**PLANNING ACT 2008
APPLICATION BY HIGHWAYS ENGLAND FOR AN ORDER GRANTING
DEVELOPMENT CONSENT FOR THE A303 SPARKFORD TO ILCHESTER
DUALLING
SUBMISSION MADE PURSUANT TO DEADLINE 8**

PLANNING INSPECTORATE REFERENCE TR010036

PLANNING ACT 2008 - APPLICATION BY HIGHWAYS ENGLAND FOR AN ORDER GRANTING DEVELOPMENT CONSENT FOR THE A303 SPARKFORD TO ILCHESTER DUALLING

SUBMISSION MADE PURSUANT TO DEADLINE 8

INSET E: EXISTING ROADS AND PROW TO BE STOPPED UP

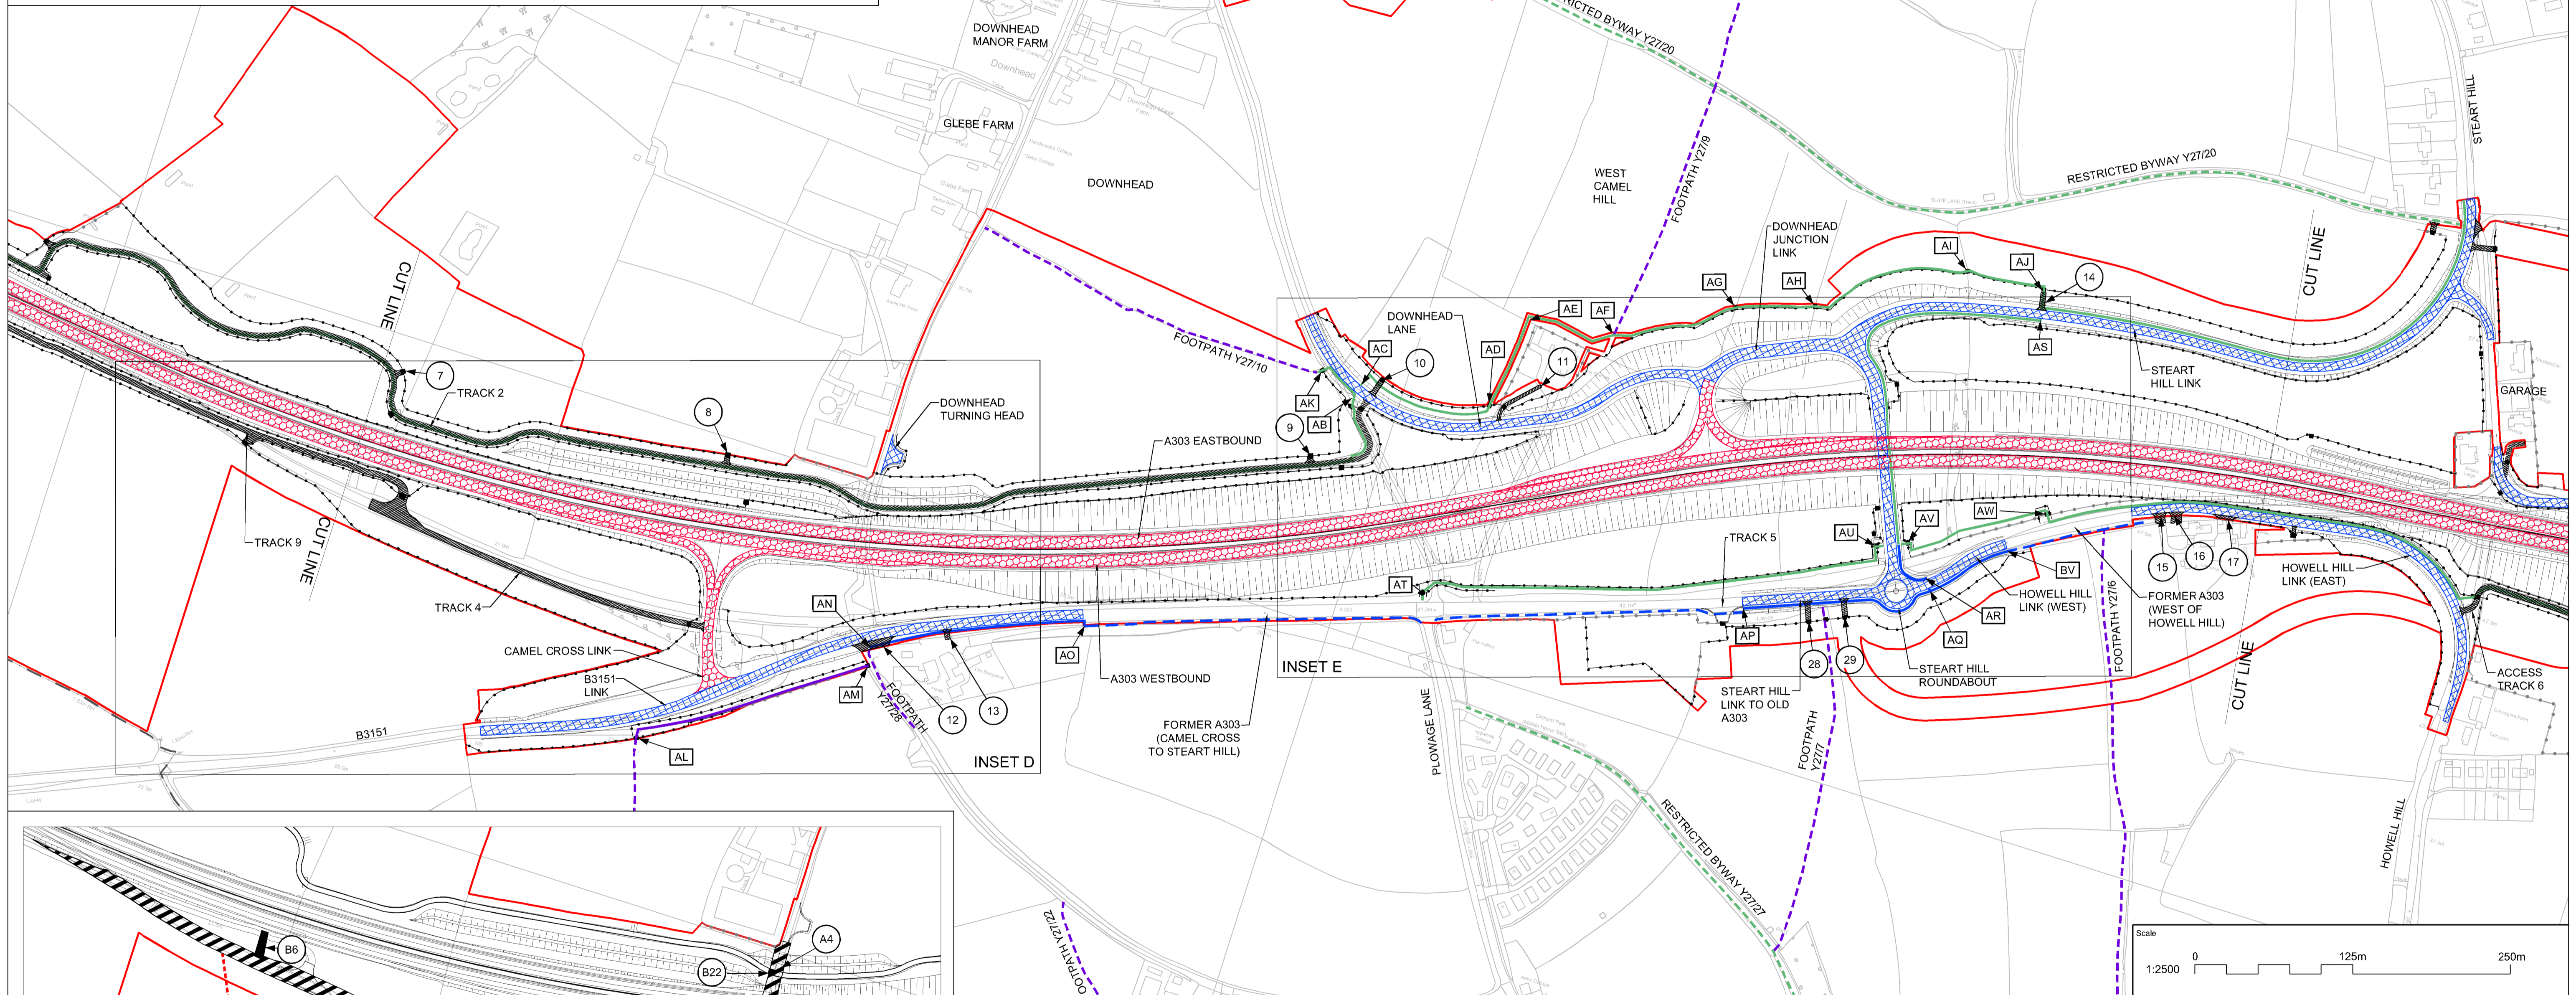
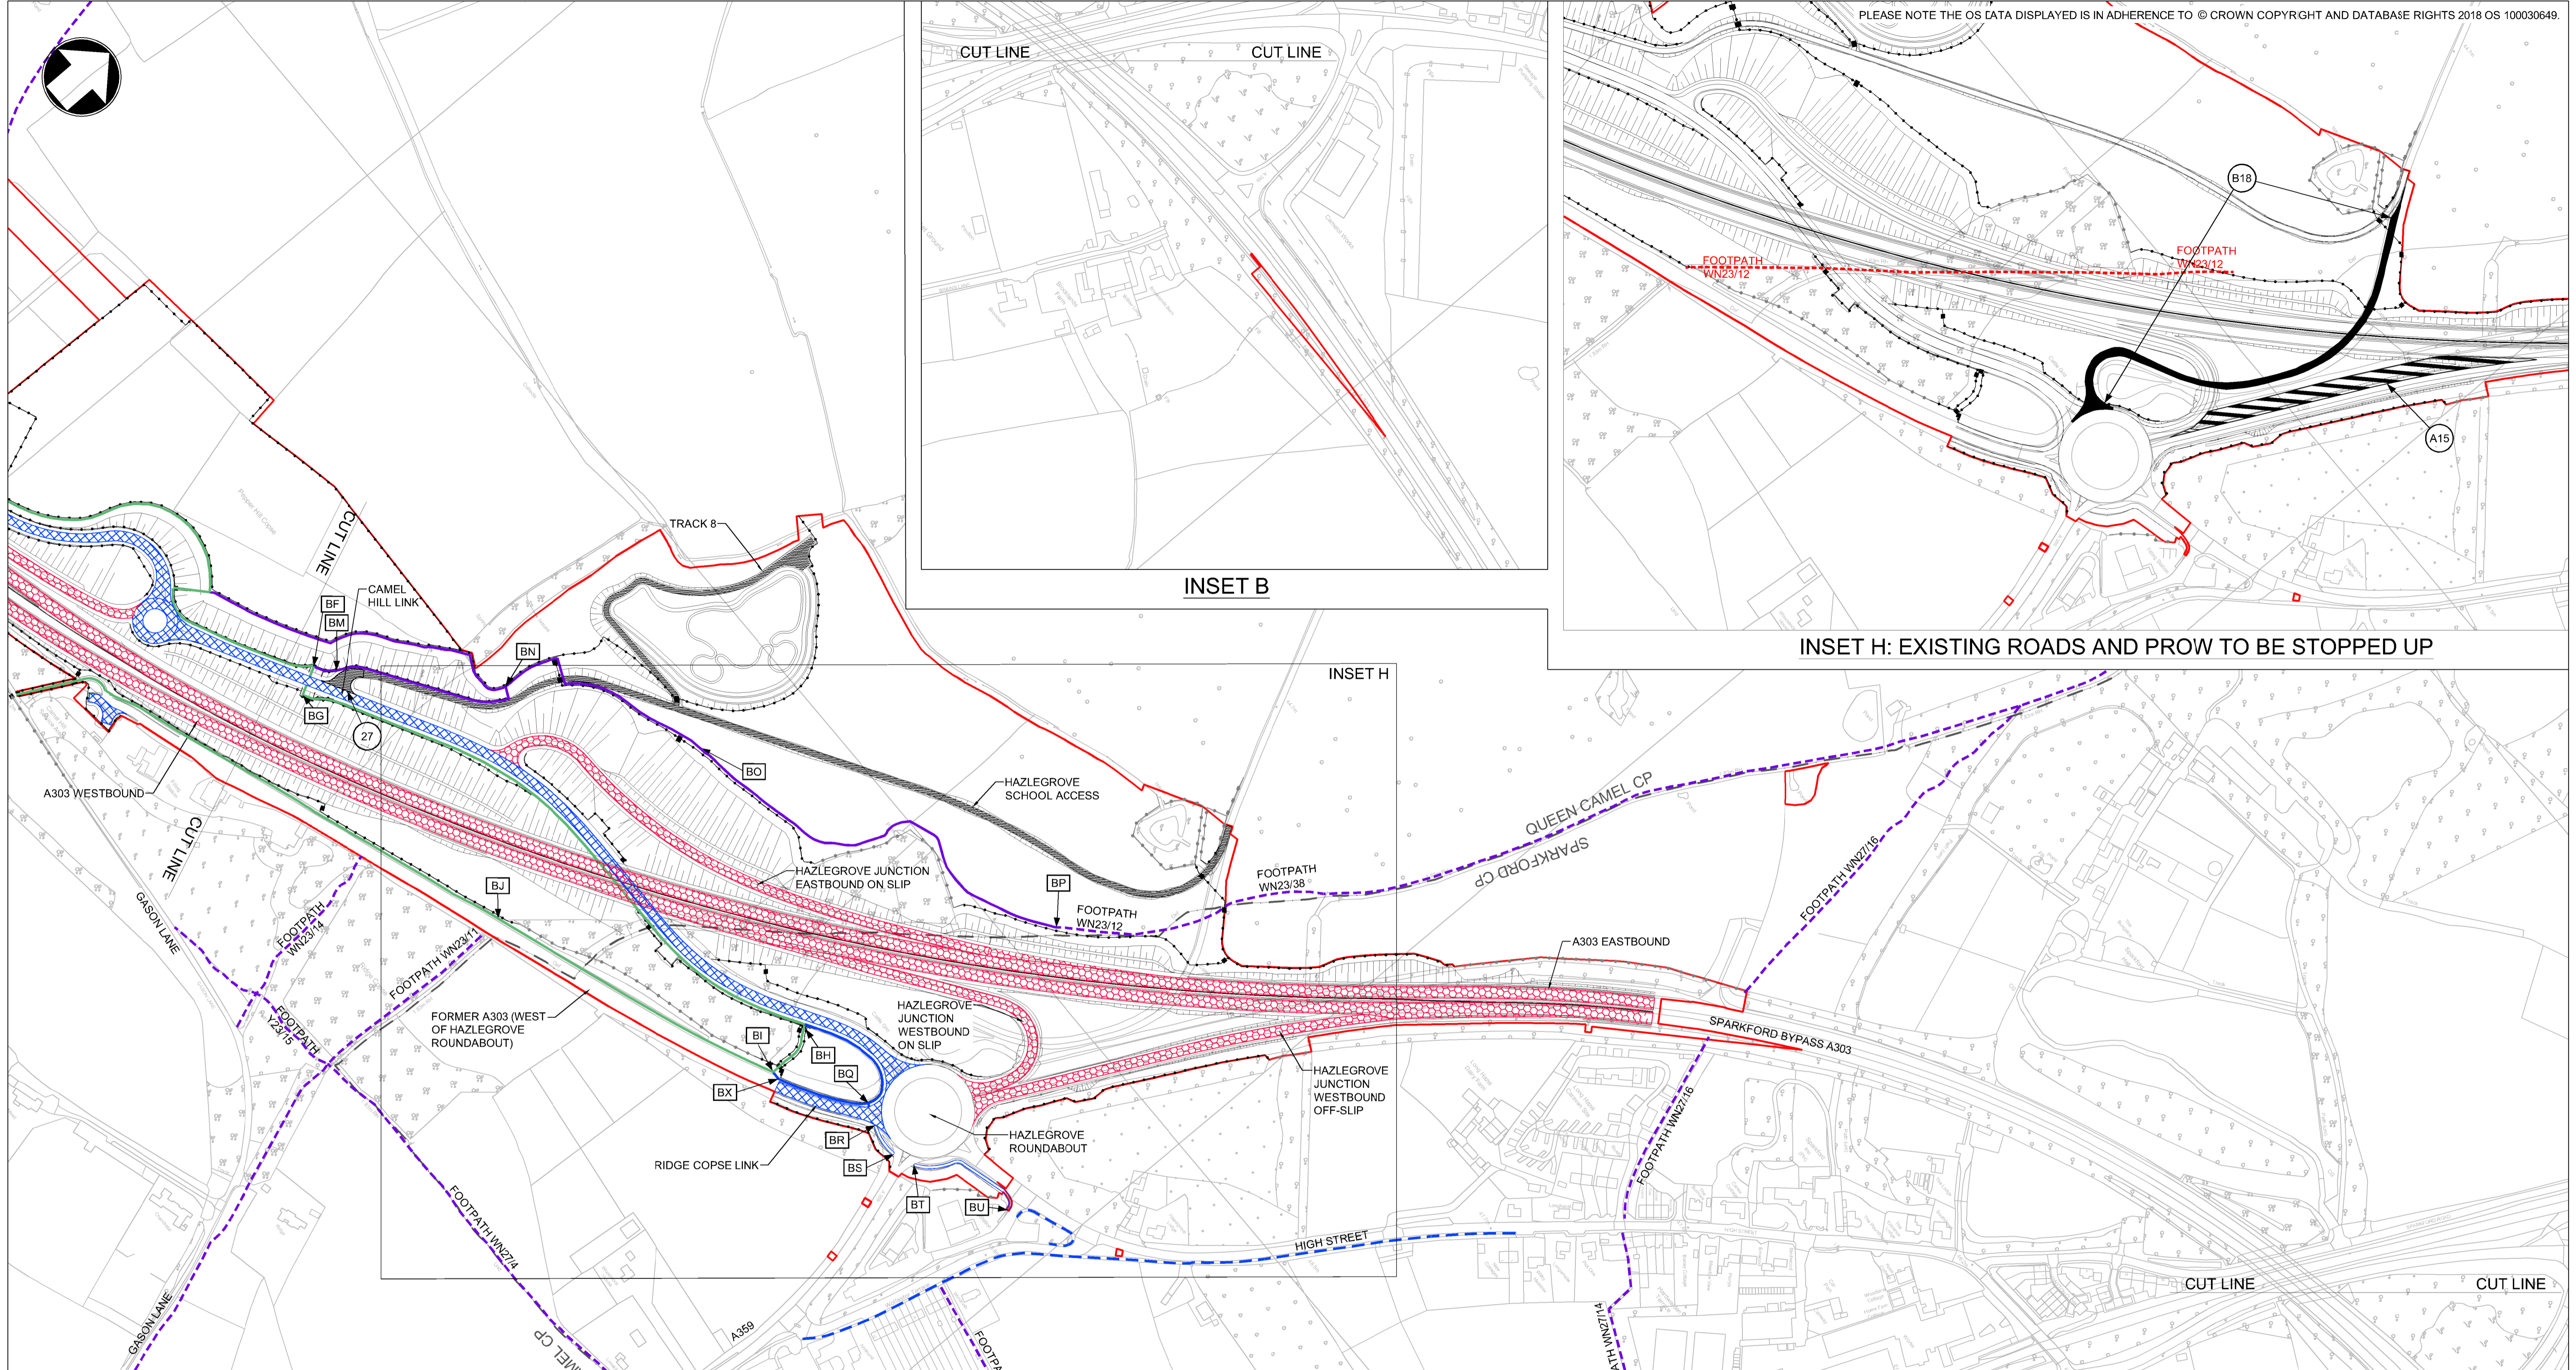
Reference	Action	Response location
Way and Access Plans		As per the County Council's deadline 6 submission, references in the DCO and the Rights of Way & Access Plans require amending; Y 27/29 should now be shown as Y 27/UN, and Y27/36 should now be shown as Y 27/29. If the County Council is to update the Definitive Map & Statement with the effect of the DCO then these changes are critical.
